**From:** Dave Thomson <dthomson@thomsondb.co.uk>  
**Sent:** 11 January 2021 17:33  
**To:** Crawley, Sarah <Sarah.Crawley@stroud.gov.uk>; \_WEB\_Planning <Planning@stroud.gov.uk>  
**Subject:** Re: S.20/1260/HHOLD alteration

- 20-0390 D05A : Original, approved drawing.
- 20-0390 D05B : With proposed minor amendment to extension roof design.

Site	Dove Cottage, The Hollies, Nailsworth, Gloucestershire GL6 0AW	Date	23.11.2020
		Sheet	20-0390 D05B
		Scale	As Shown@A1
		Title	As Shown

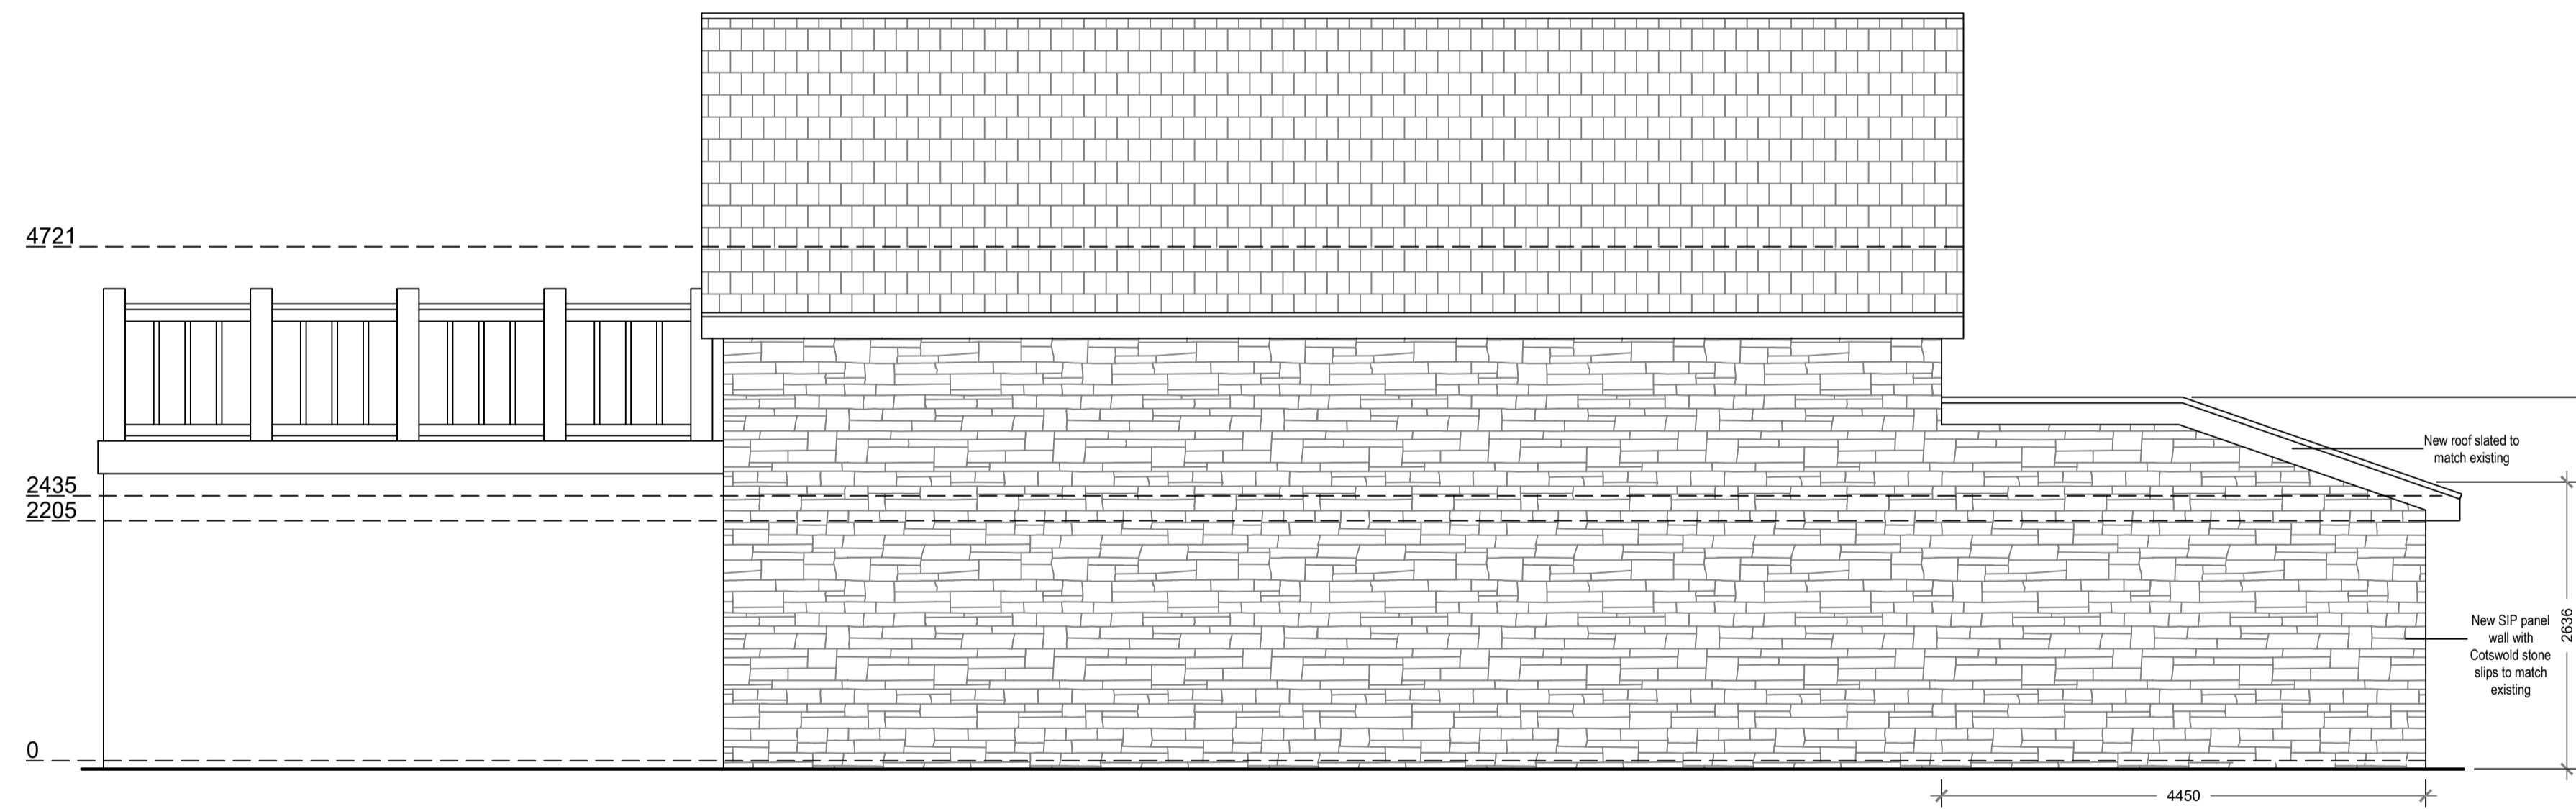
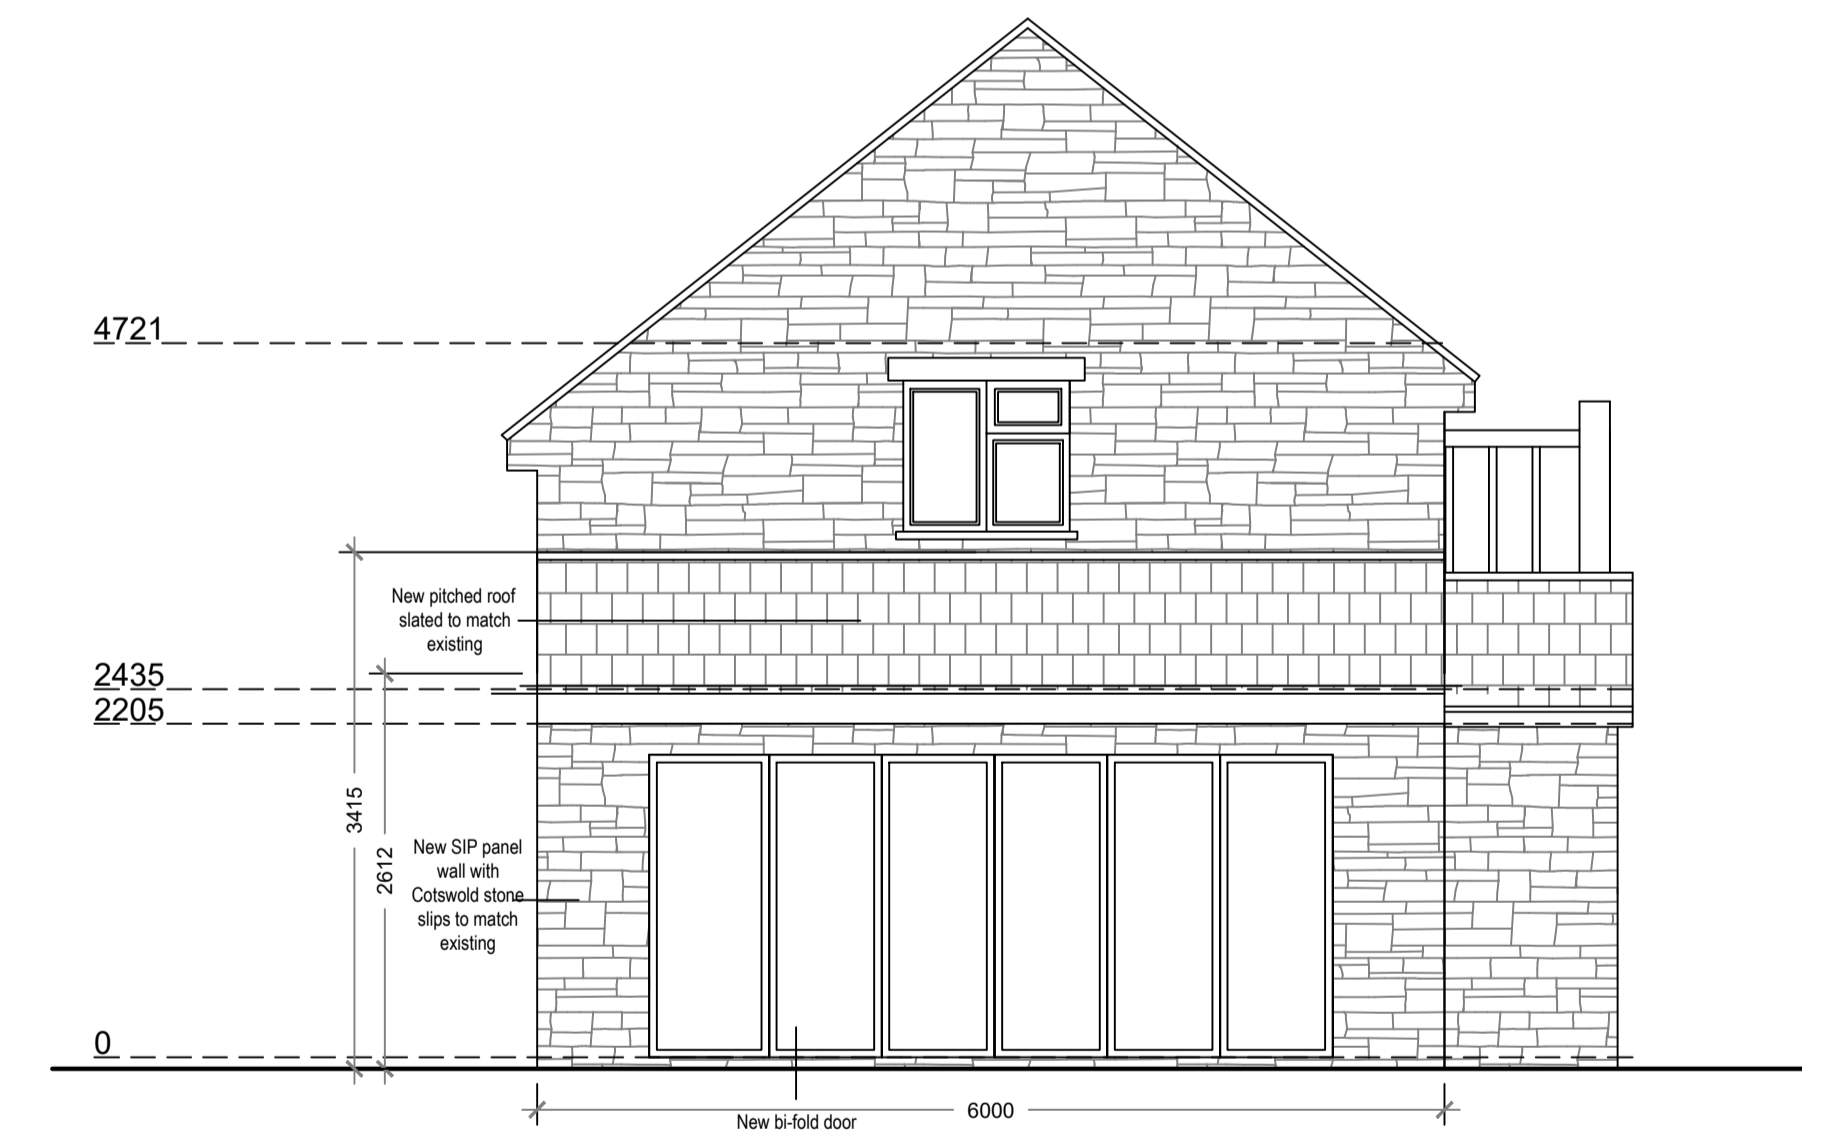
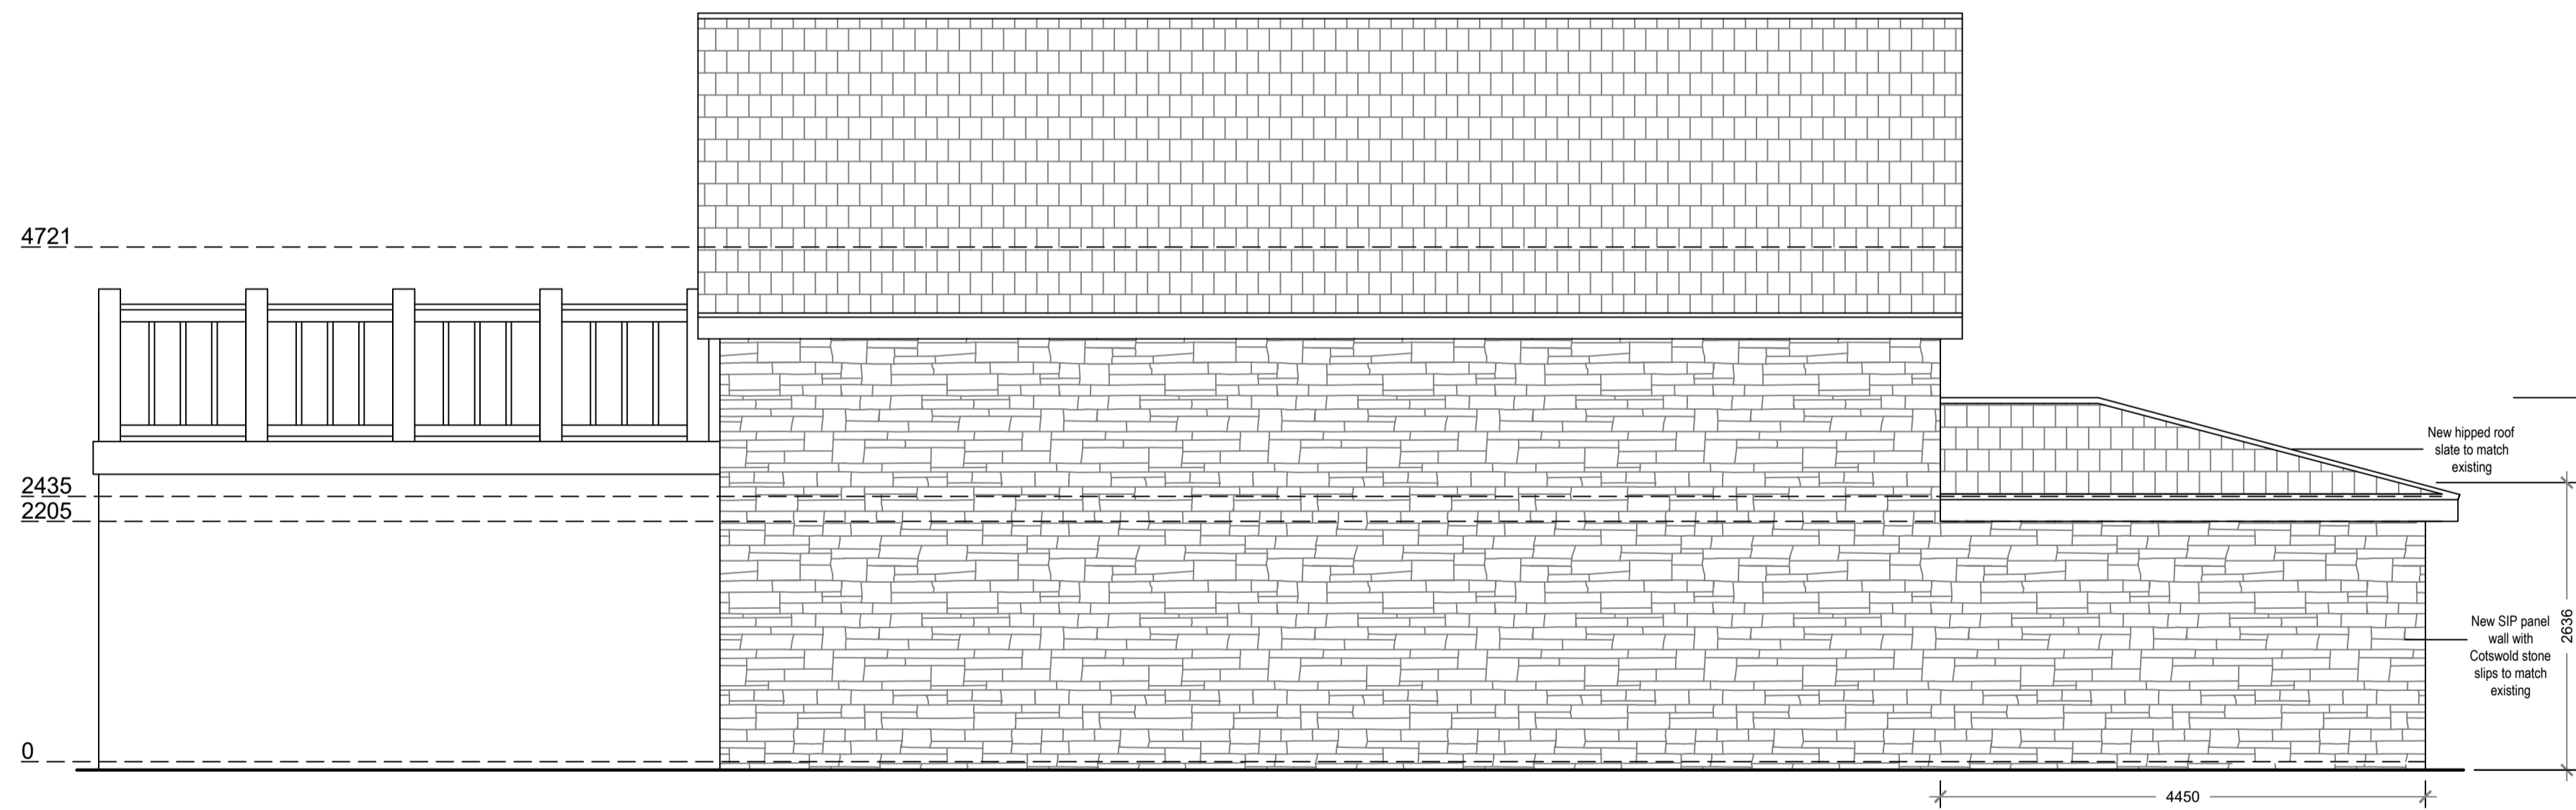
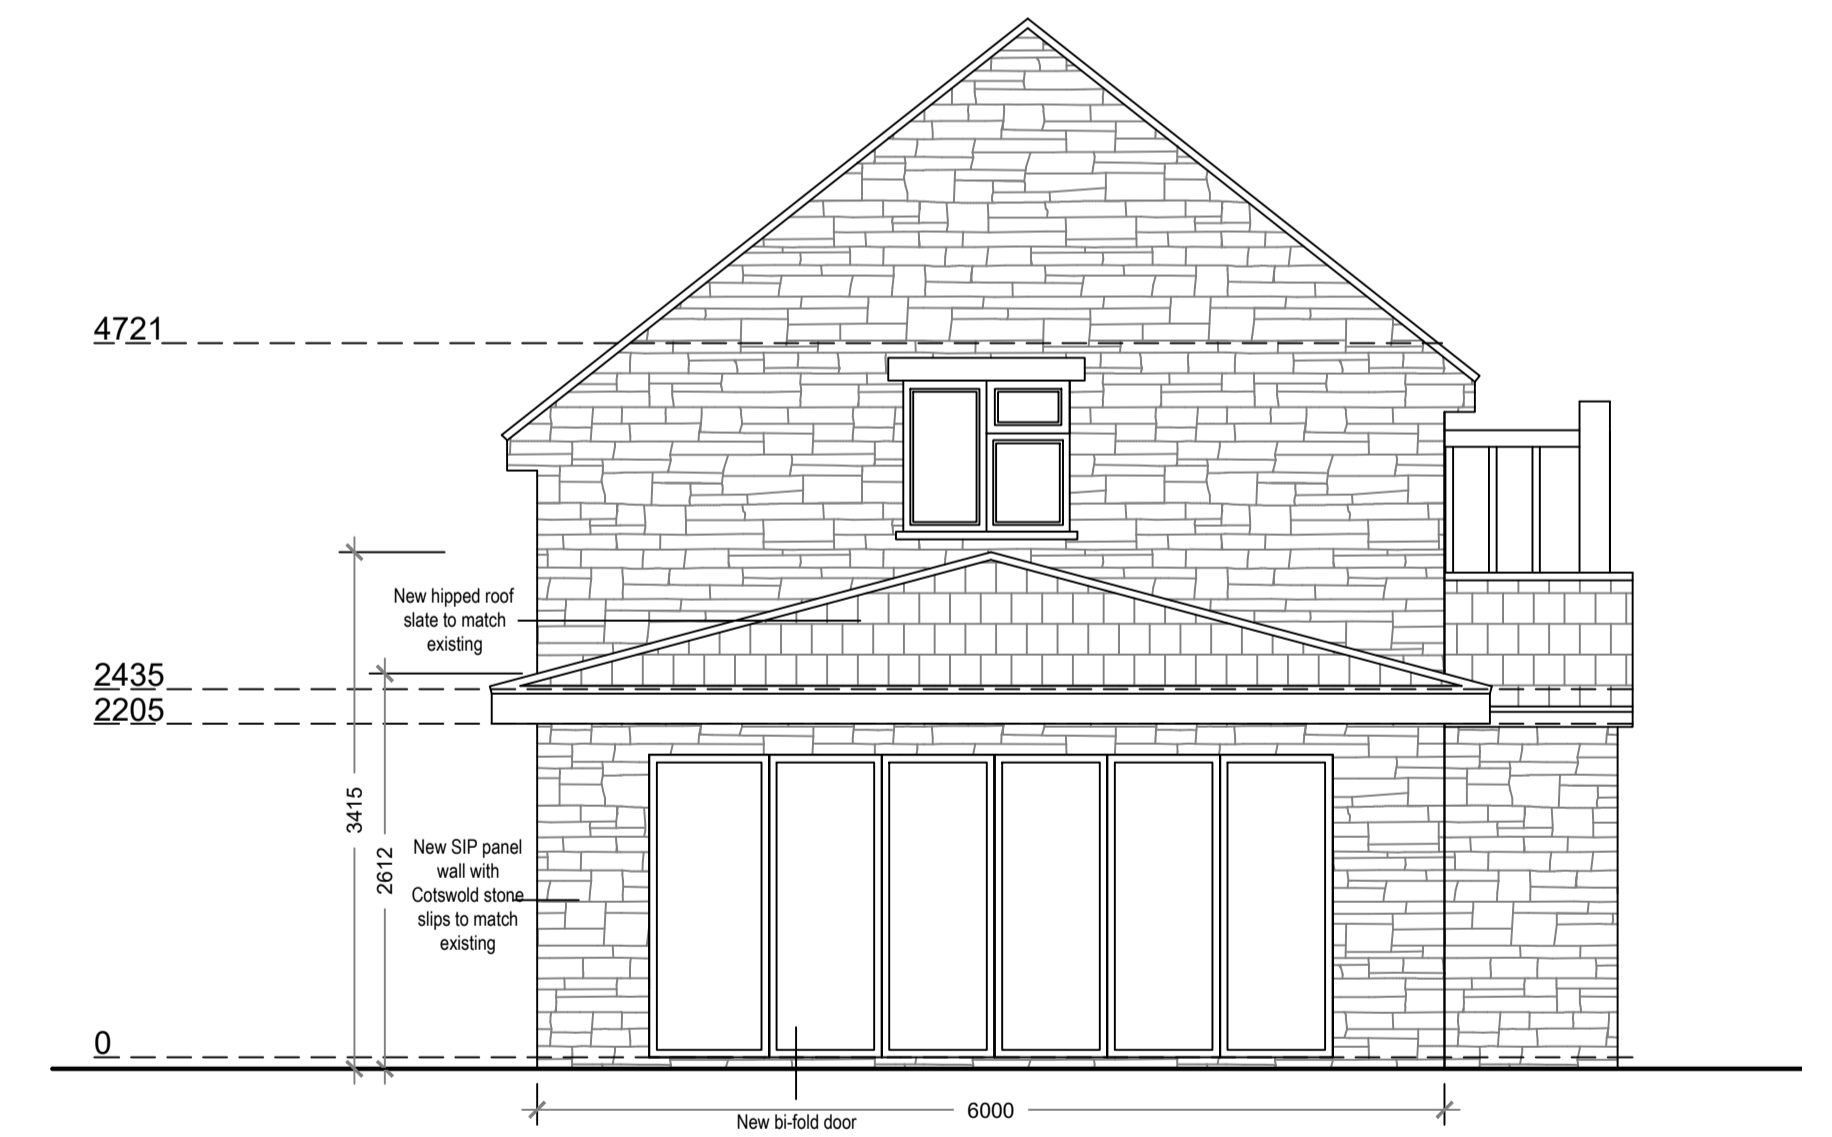
I hope you can help direct me to the relevant person. I am working with my client on an extension project and there seems to be some confusion about the roof. It seems that the incorrect roof design was submitted and we would like to know if we can build the attached hip roof rather than the single pitch that was approved?
